**CITY OF PORTLAND, MAINE  
DEPARTMENT OF PUBLIC WORKS  
OPERATIONS/ENGINEERING - INSPECTIONS**

**TO:** Bill Bray, P.E., Director of Public Works  
**FROM:** Nancy L. Knauber, Associate Engineer  
**DATE:** July 13, 1998  
**SUBJECT:** Redlon Park, Weekly Report - Inspected July 13, 1998  
Ric Weinschenk - 828 - 3900

TO: Sarah Hopkins, Senior Planner *SB (SO)*  
FROM: Steve Bushey, Development Review Coordinator  
DATE: March 14, 1997  
RE: Redlon Park

**TO:** Sarah Hopkins, Senior Planner  
**FROM:** Tony Lombardo, Project Engineer *ALH*  
**DATE:** March 13, 1997  
**SUBJECT:** Redlon Park - P.R.U.D. Subdivision

C1

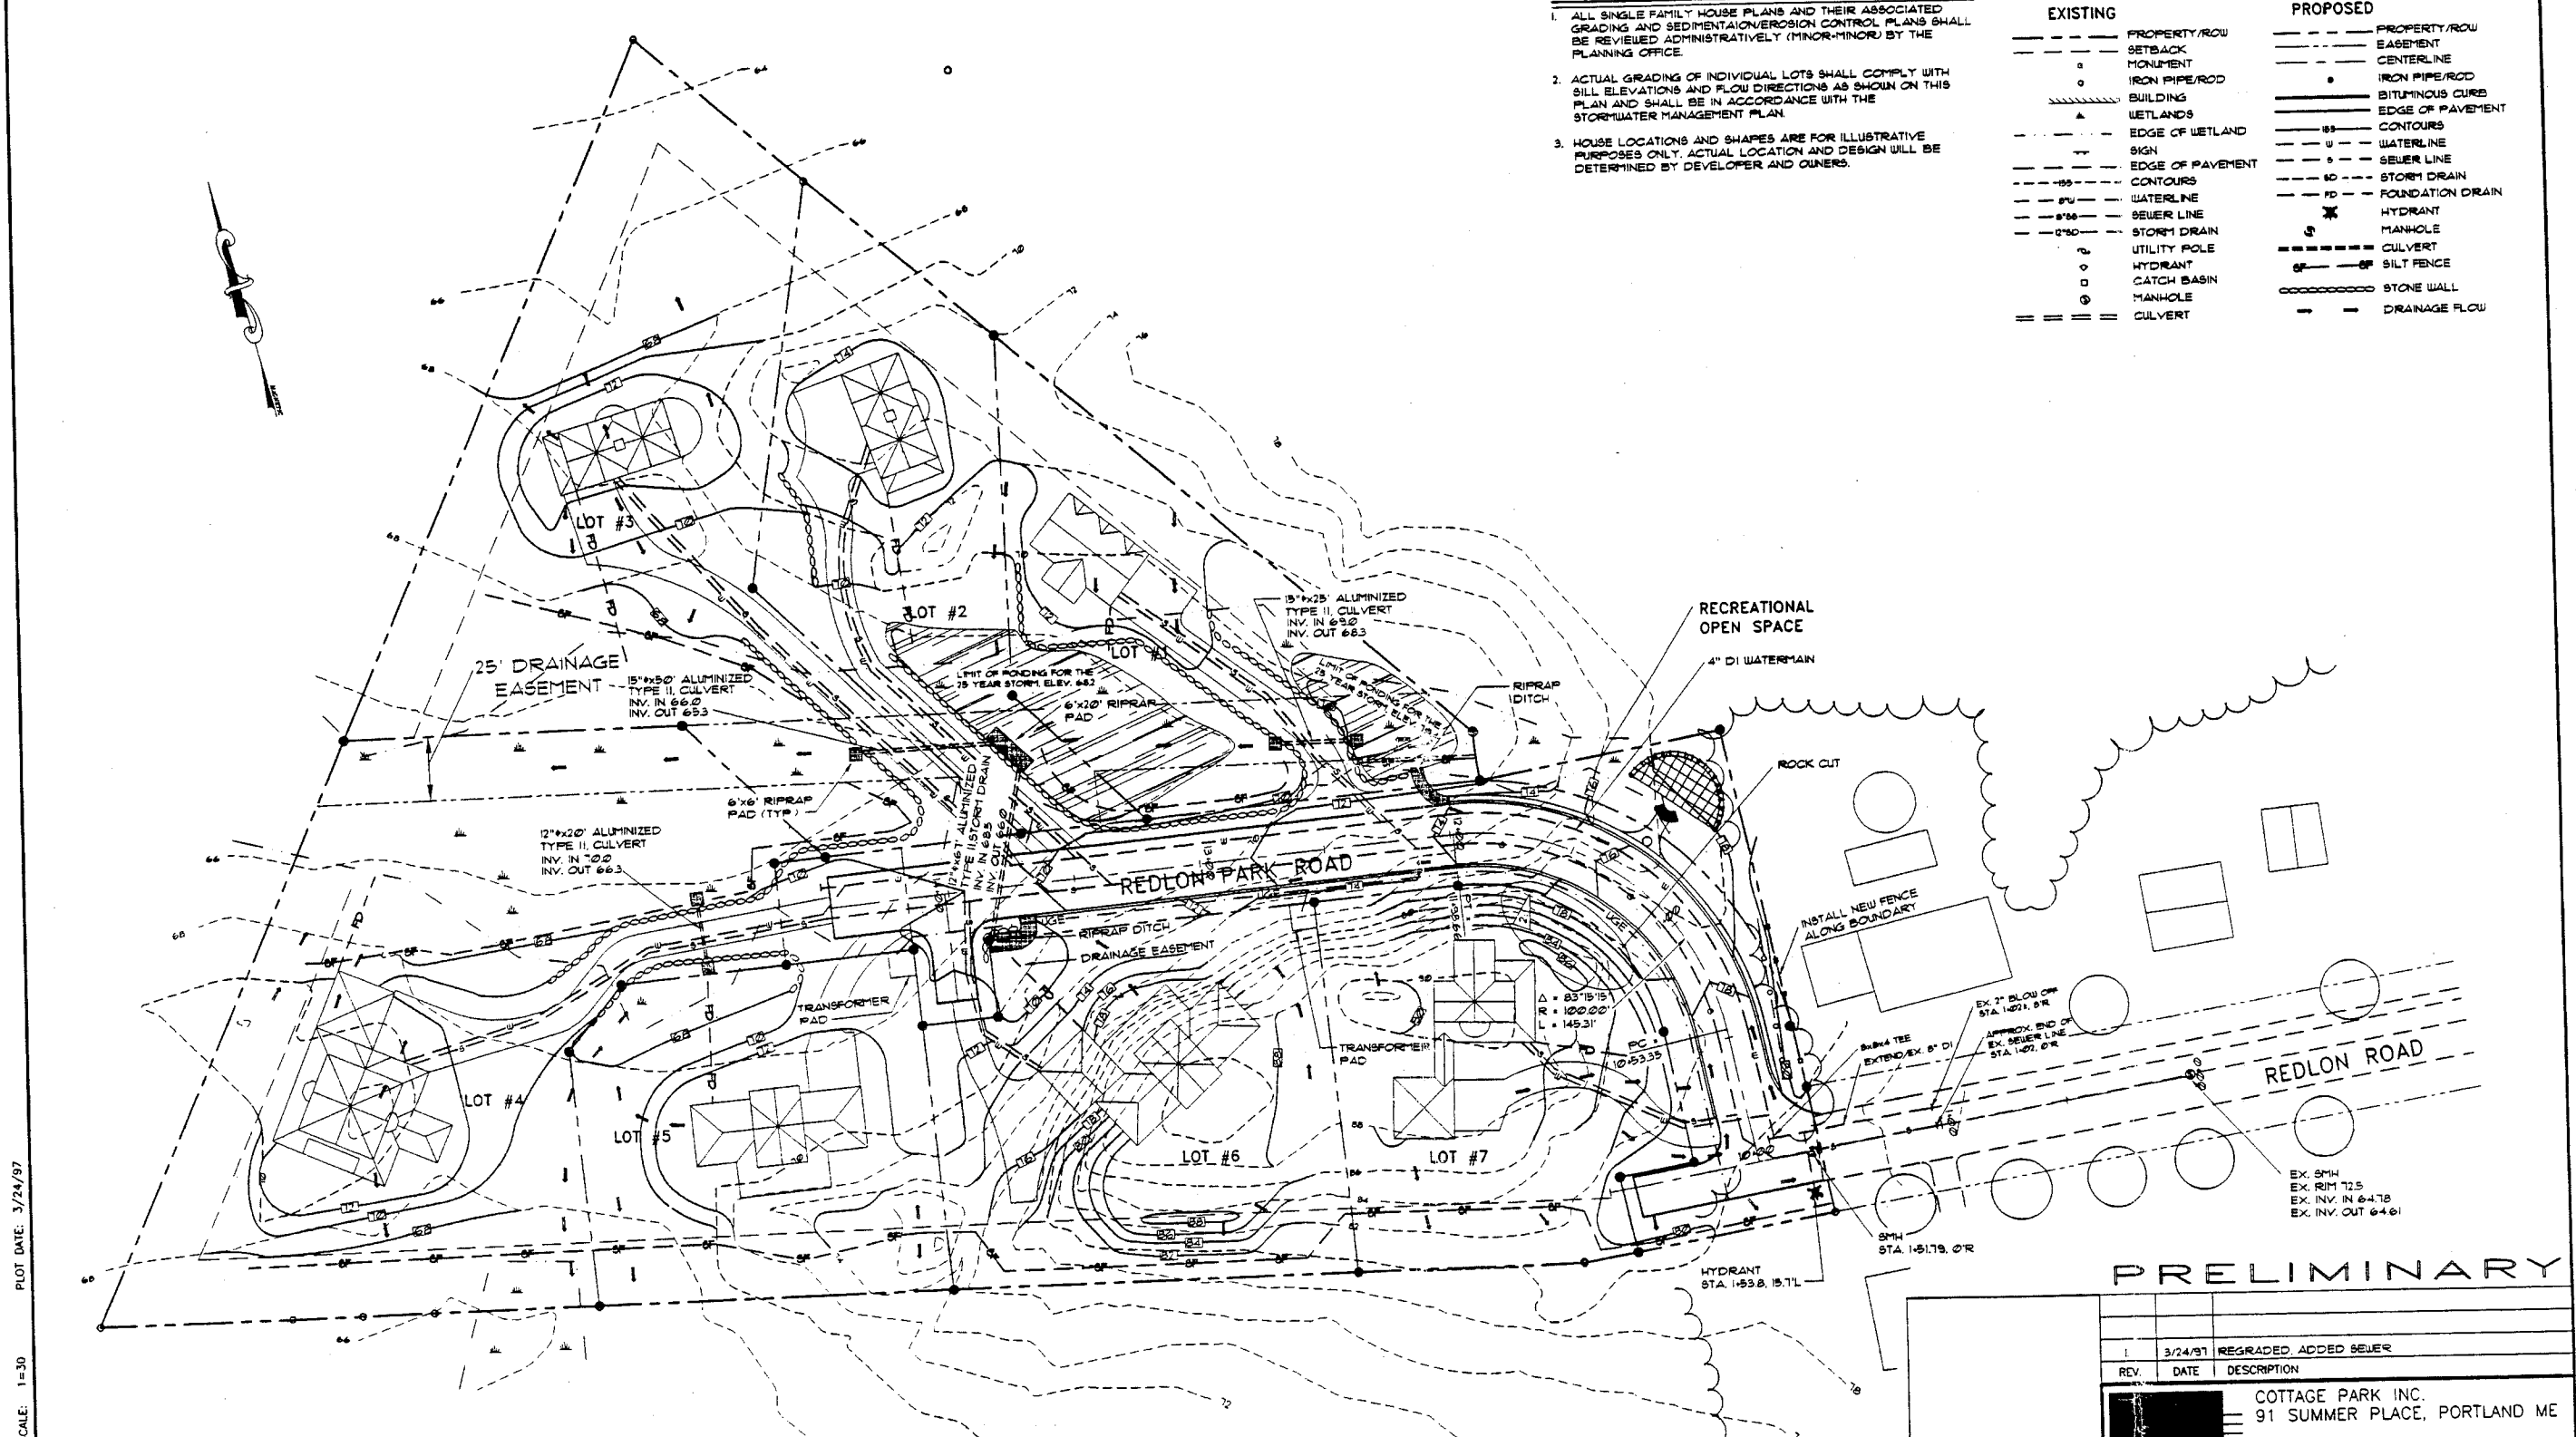
Sheet C1

1. Note 9 of the general notes states that the lots will be served by public water and sewer. This should be noted that the utilities within the PRUD are private but will be connected to the public systems in Redlon Road.
2. The applicant should identify the wetland impacts and type of NRPA permit which will be required. Receipt of an NRPA permit should be considered a condition of approval.
3. Note 18 states that ". . . maintenance of the stormwater structures outside of common areas shall be the responsibility of the individual lot owners." This is a concern since individual property owners

cannot be generally relied upon to provide such maintenance. Perhaps this should be the Association's responsibility.

4. The plan identifies a stream passing through the middle of the site. The applicant should provide a jurisdictional opinion on this stream from either the ME DEP or a wetland scientist.
5. The property line symbol is identified as an easement line in the legend.
6. The minimum building setback from external subdivision property lines is identified as 25' on Plan C1, but is identified as 20' on page 5 of Exhibit B - Design Review contained in the application package. This should be clarified.
7. The wetland limits in the vicinity of proposed lot #5 may be incorrectly plotted. The wetland scientist should confirm the accuracy of the wetland limit plotting.
8. A copy of the wetland report should be submitted to the City.

C2

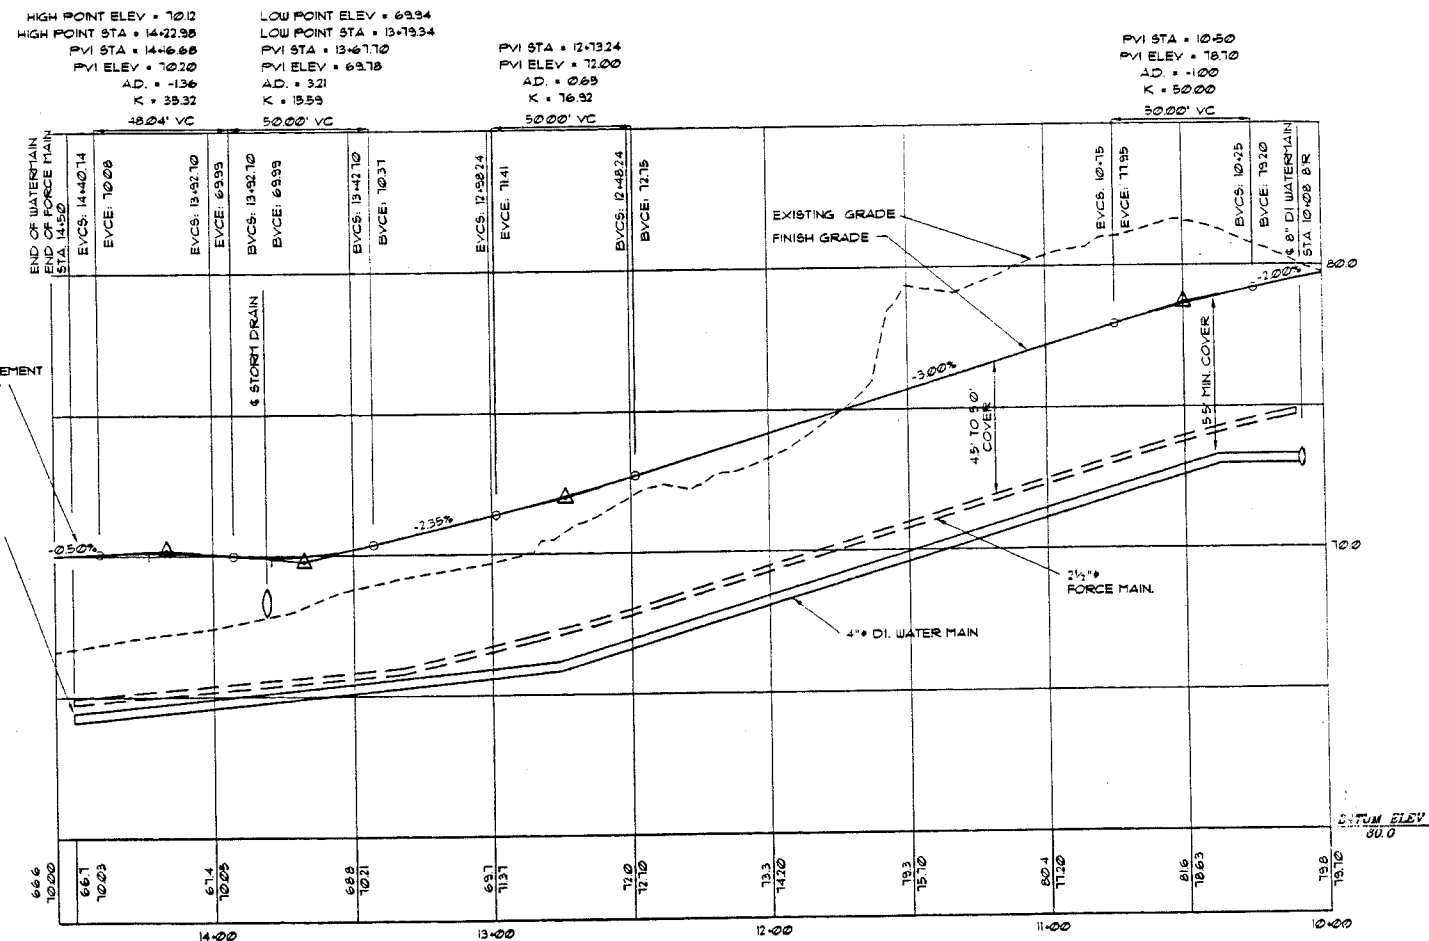
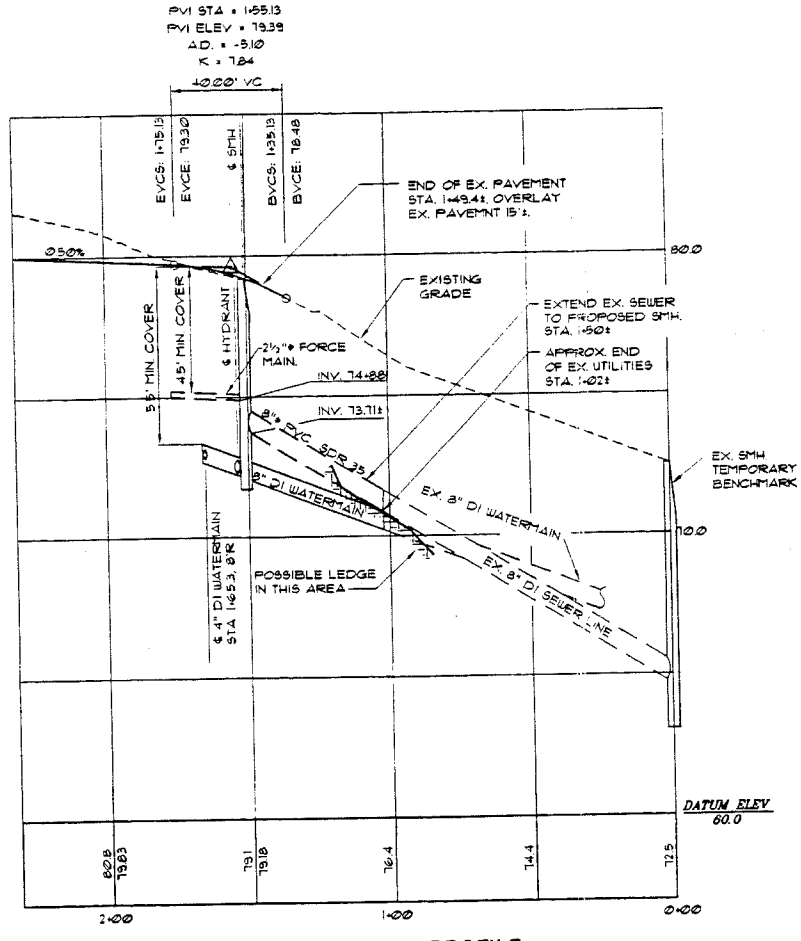
#### Sheet C2

1. A grading plan for the road and lots should be prepared and provided for review.
2. It appears, based on the road profile, that the proposed road grading will extend beyond the adjacent property line to the right of approximately station 12 + 00. This will require an easement or the construction of a retaining wall.

3. The limits of all ponding areas at each culvert should be identified as part of the stormwater management review.
4. Only one hydrant is identified at the end of Redlon Road. The Fire Department should review this and determine if a second hydrant is necessary.

5. The total length of Redlon Road and Redlon Park Road appears to be approximately 750 feet. Is this total dead end length acceptable to the City?
6. Note #2 on Sheet C2 states the flow directions are shown on the plan. None were shown.

7. It appears that at least 5 house lots will require an individual pump for their sanitary sewer. The applicant should provide data for these services including long term maintenance provisions and association responsibilities.

Sheet C-2 - "Site Plan"

- o ~~CB#1 should be revised to drain northerly towards Lot #3 and outletting where the proposed 15" diameter x 65 foot long culvert outlets. A drainage easement is required where the CB#1 outlet pipe crosses Lot #3.~~
- o How does the applicant propose to provide sewer service to Lots #1-7.
- o Applicant should specify invert elevations of proposed culverts. In addition, applicant should specify the elevation limits of the proposed ponding areas #1 and #2 as described in the stormwater narrative.
- o Applicant should show on site plan the limits of fill that will occur in order to construct Redlon Park Road. This is best accomplished by drawing proposed grade lines on the plan view of the road.

C5

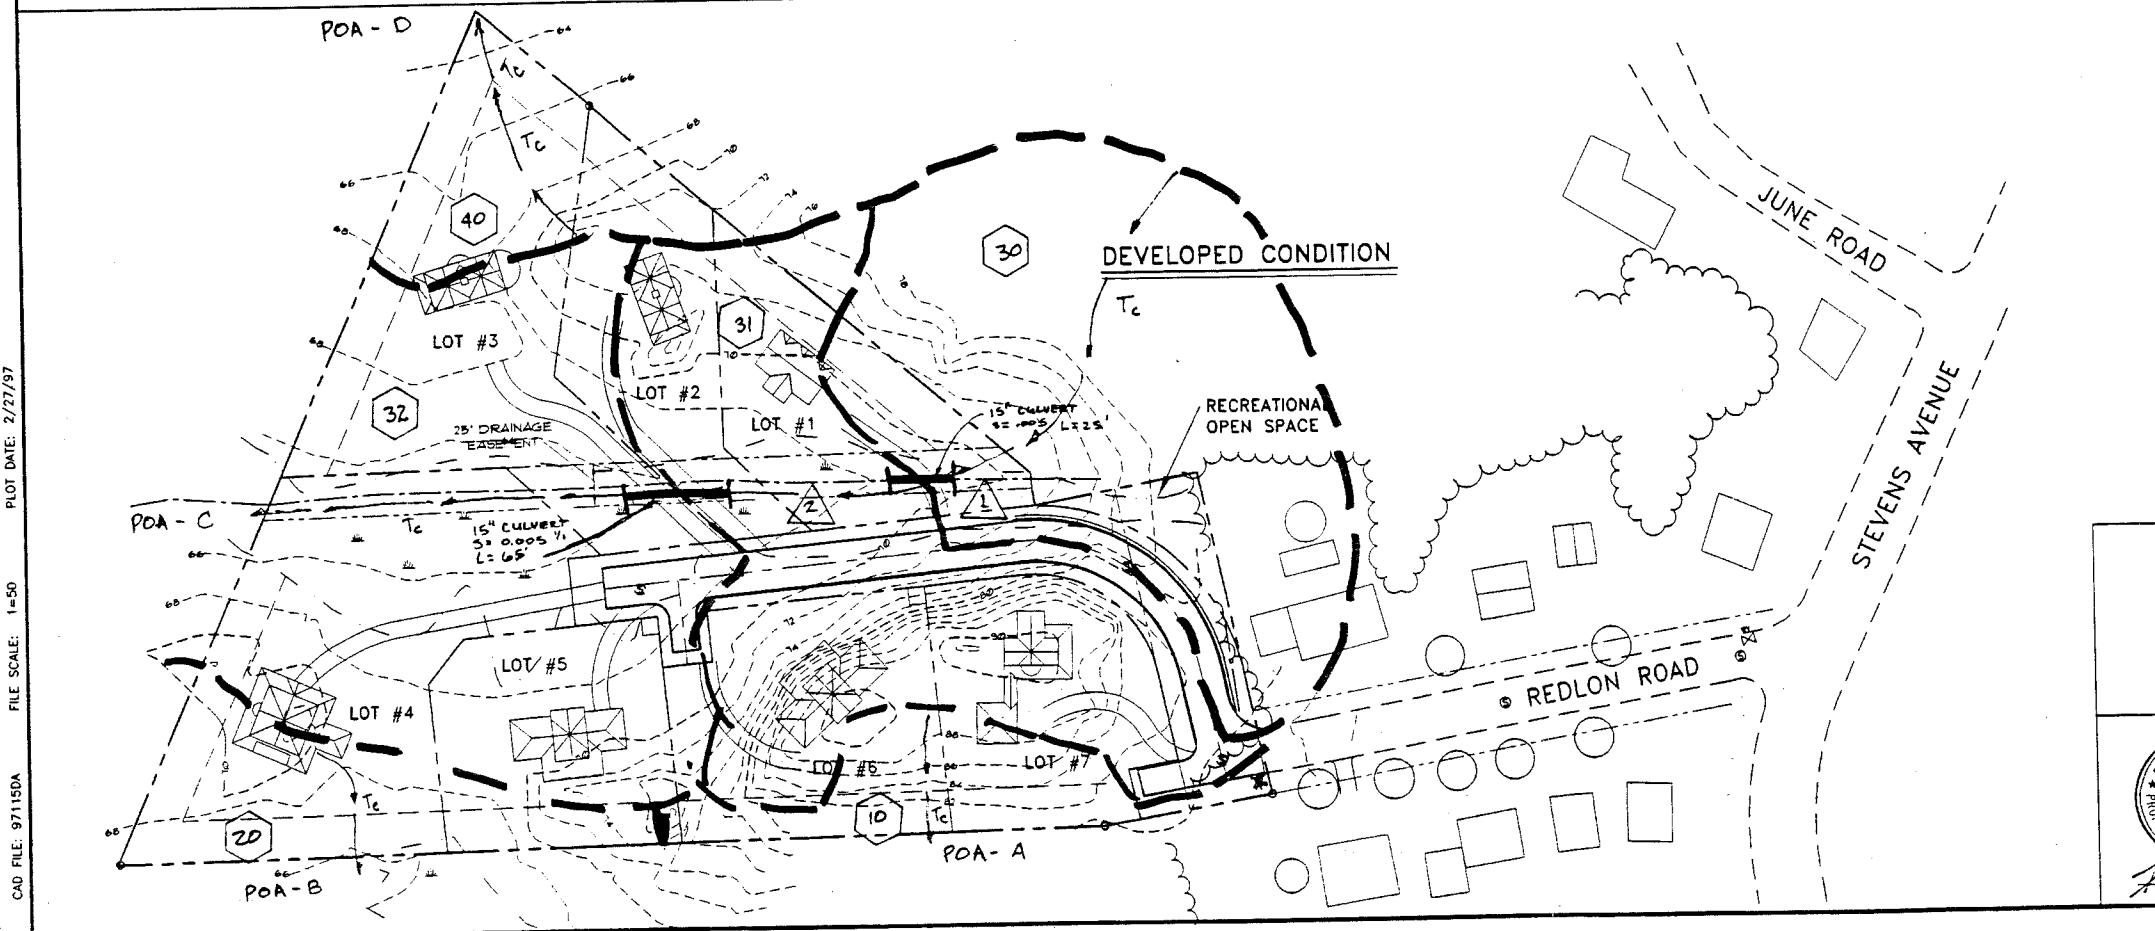
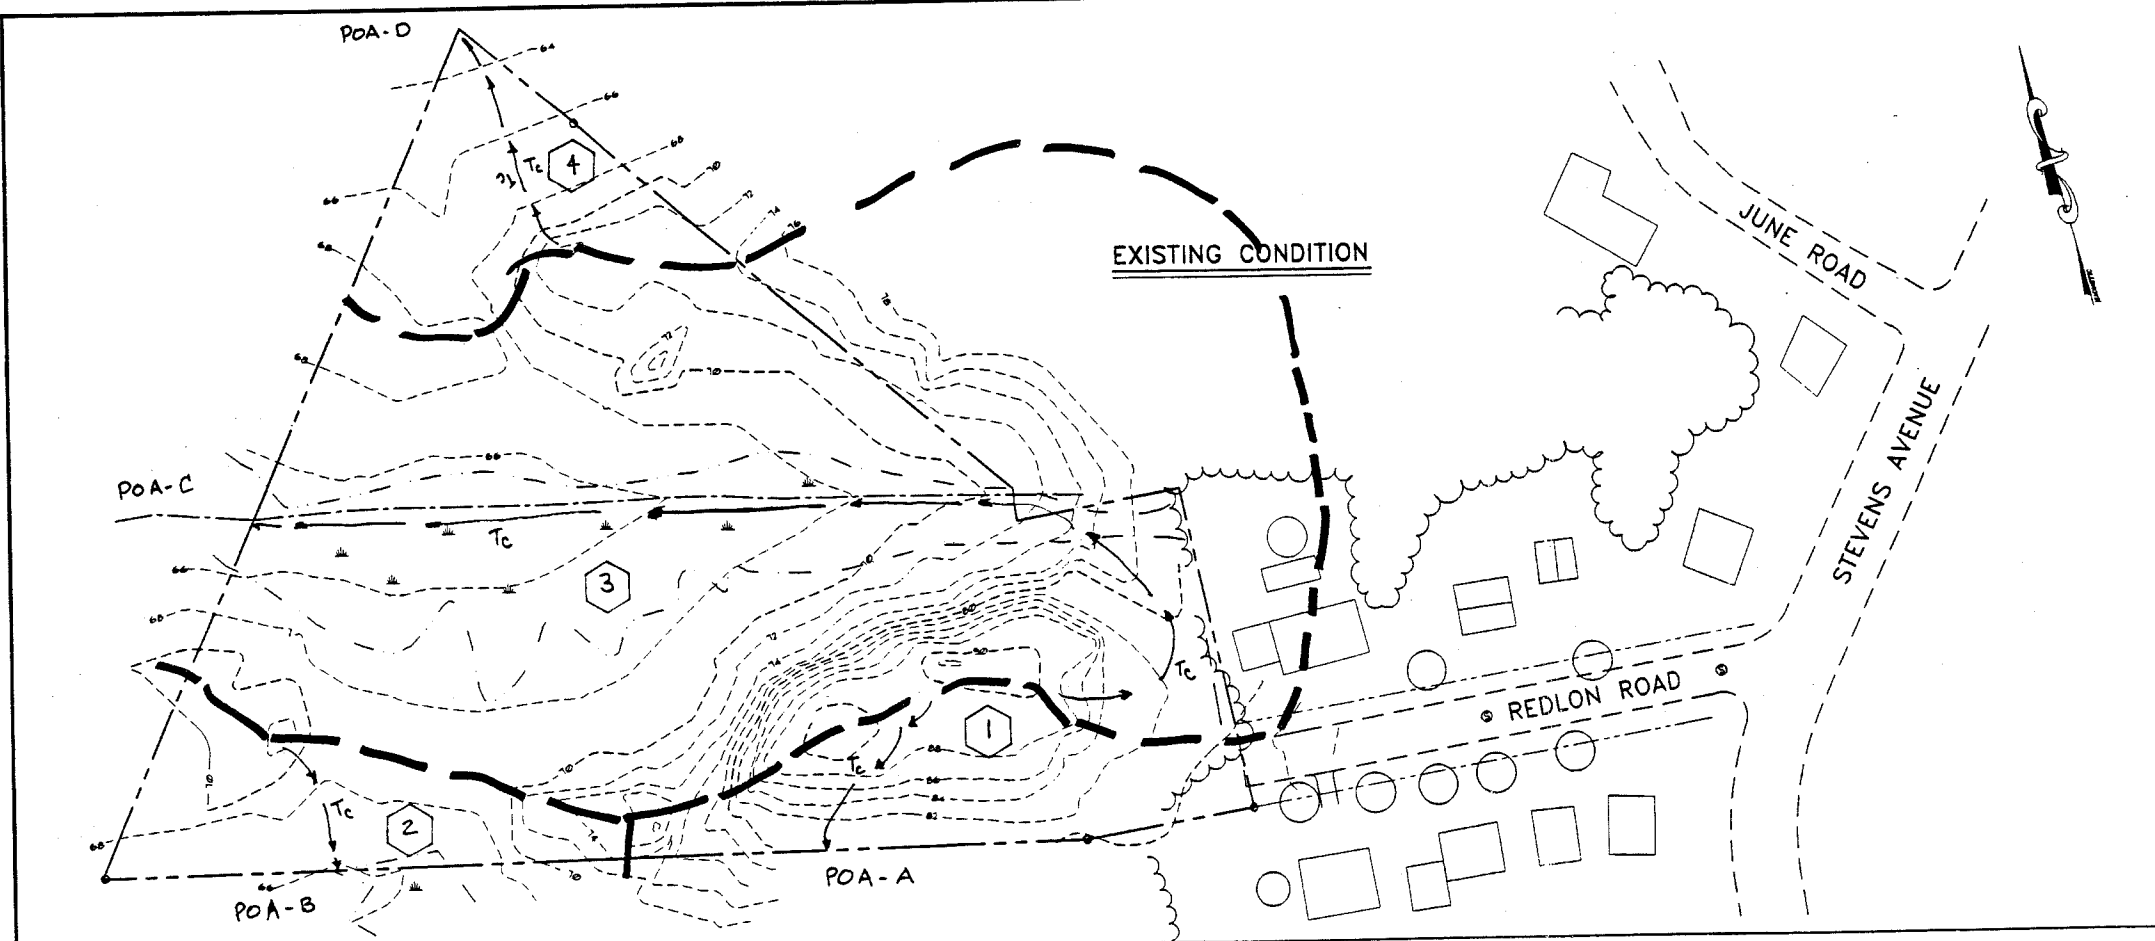
#### Sheet C5

1. Two type "E" catchbasin details are shown on Sheet C5. The catch basin with the sump should be provided. It is noted that the granite inlet stone must also be provided.
